From: Sarah Burrow <Sarah.Burrow@arun.gov.uk>
Sent: 25 August 2021 15:16
To: Planning.Responses <Planning.Responses@arun.gov.uk>
Cc: Amber Willard <Amber.Willard@arun.gov.uk>
Subject: RE: Planning Consultation on: Y/114/21/DOC

Engineers Comments Regarding Surface Water Drainage

Application No: Y/114/21/DOC

Description of Works: Approval of details reserved by condition imposed under Y/42/20/PL relating to condition 3-surface water drainage.

Client **Mr Brenden Brogan**
Drawing Title **Surface Water Drainage**

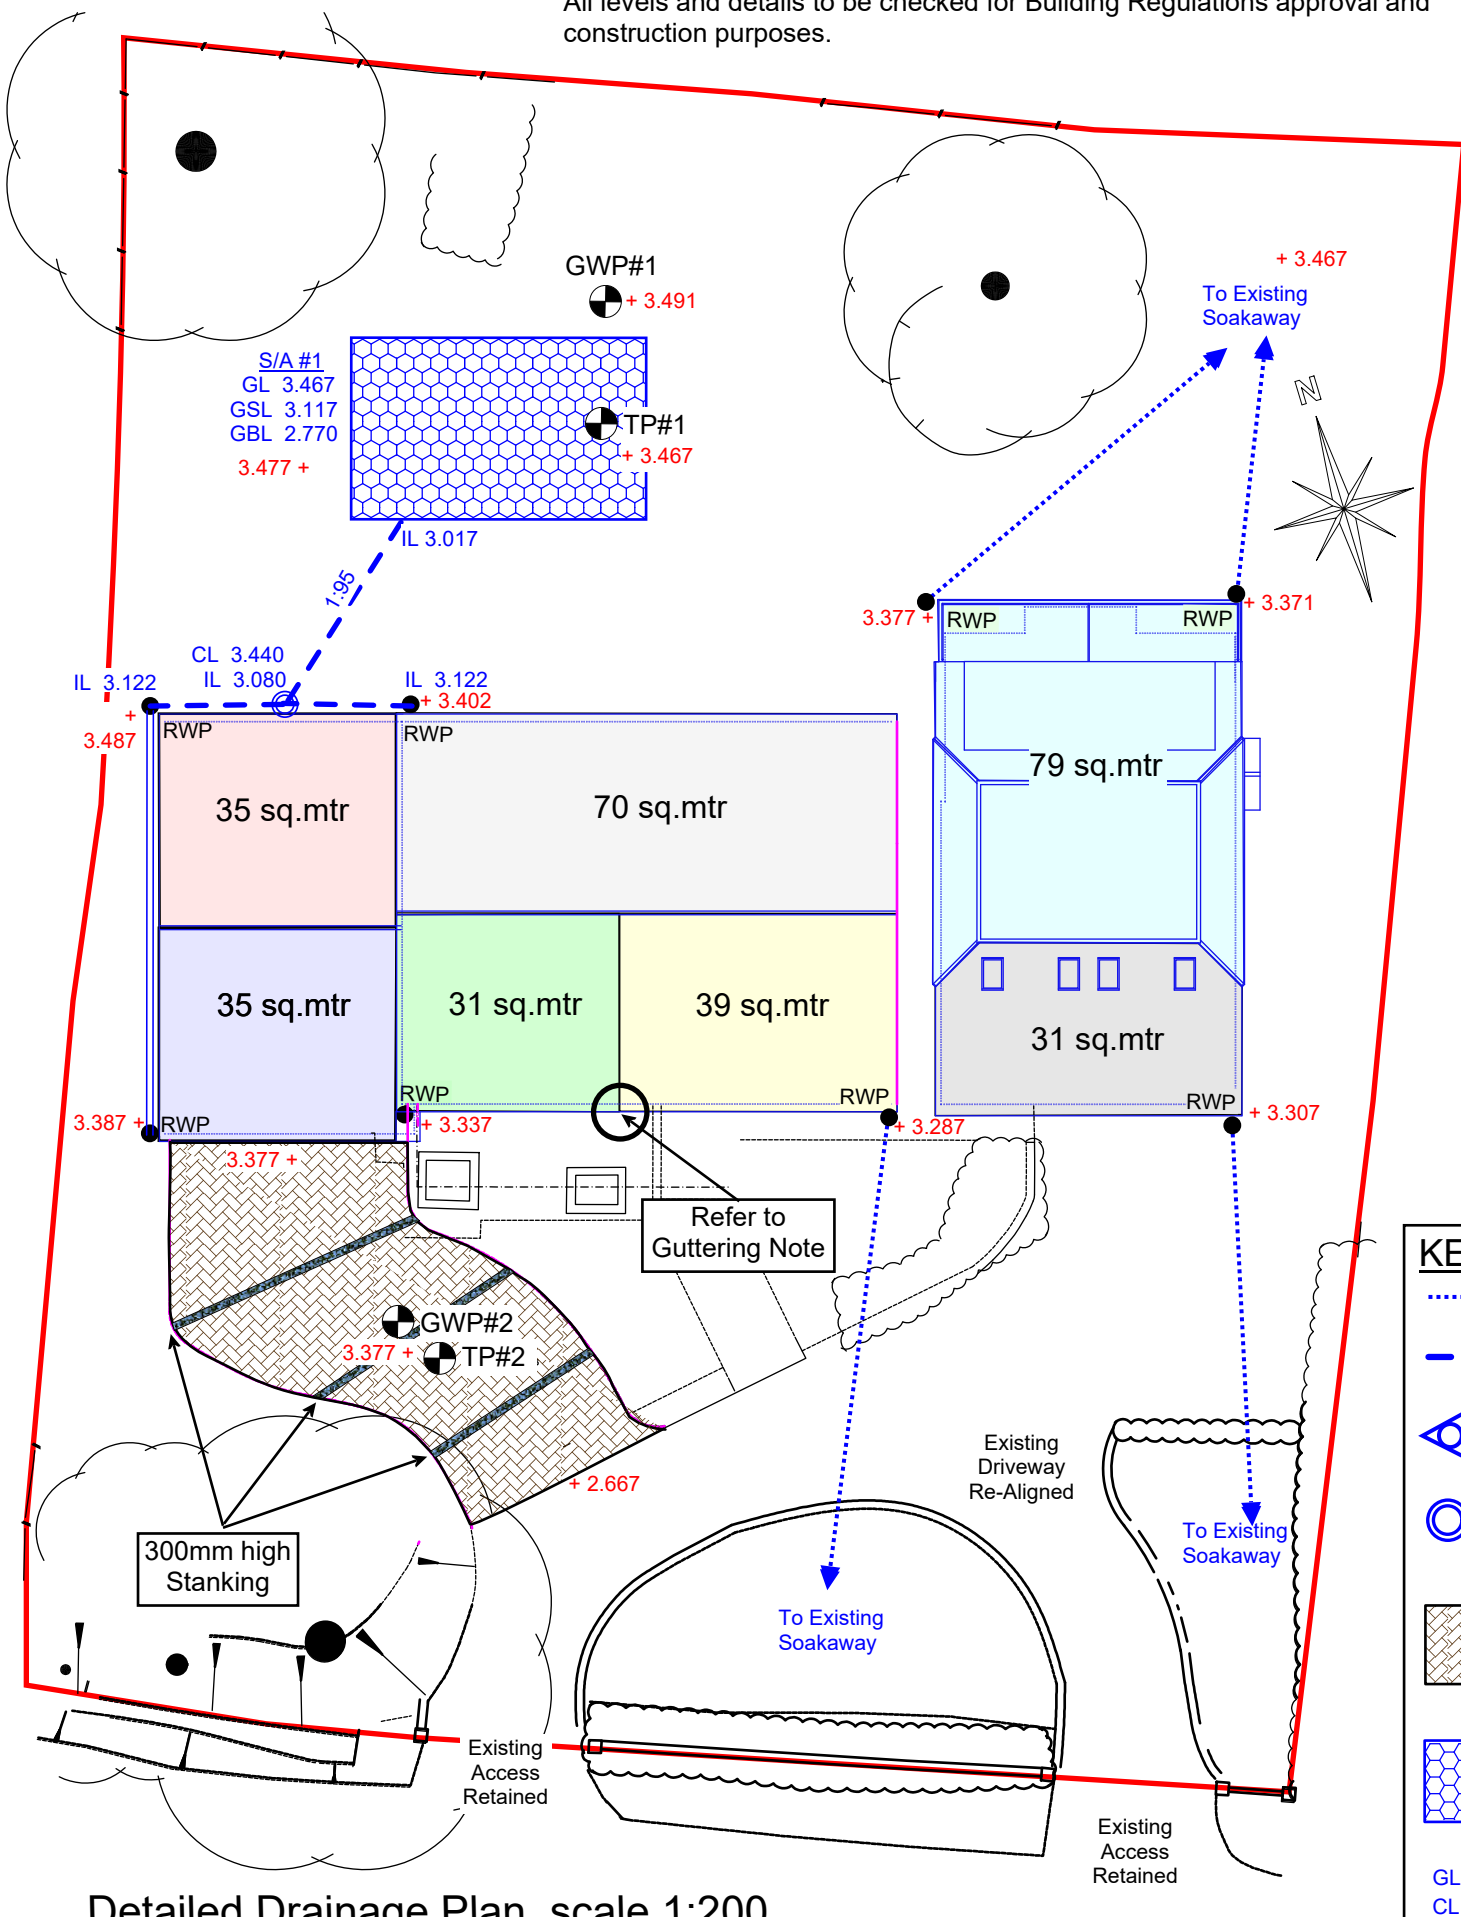
The submission is generally acceptable and I recommend that Condition 3 relating to Y/42/20/PL is discharged. However, I would ask that the applicant's Engineer contact me to clarify the reasoning behind the dates of infiltration testing. I would expect with favourable rates of $y \times 10^{-5}$ the testing would be carried out on the same day in line with the principles of BRE DG365. Where this was not possible (at the front of the site) due the length of drain time I would expect the testing to be done on consecutive days which was not the case here.

On balance I believe the design is adequate and an appropriate factor of safety has been applied but I would want to see all testing carried out as close together as possible for future applications, in line with the guidance in BRE DG 365.

Please ensure all surface water drainage is constructed in accordance with the following documents:

- Surface Water Drainage MGS-Y/42/20-Rev02
- Constructional Details MGS-Y/42/20-Rev02
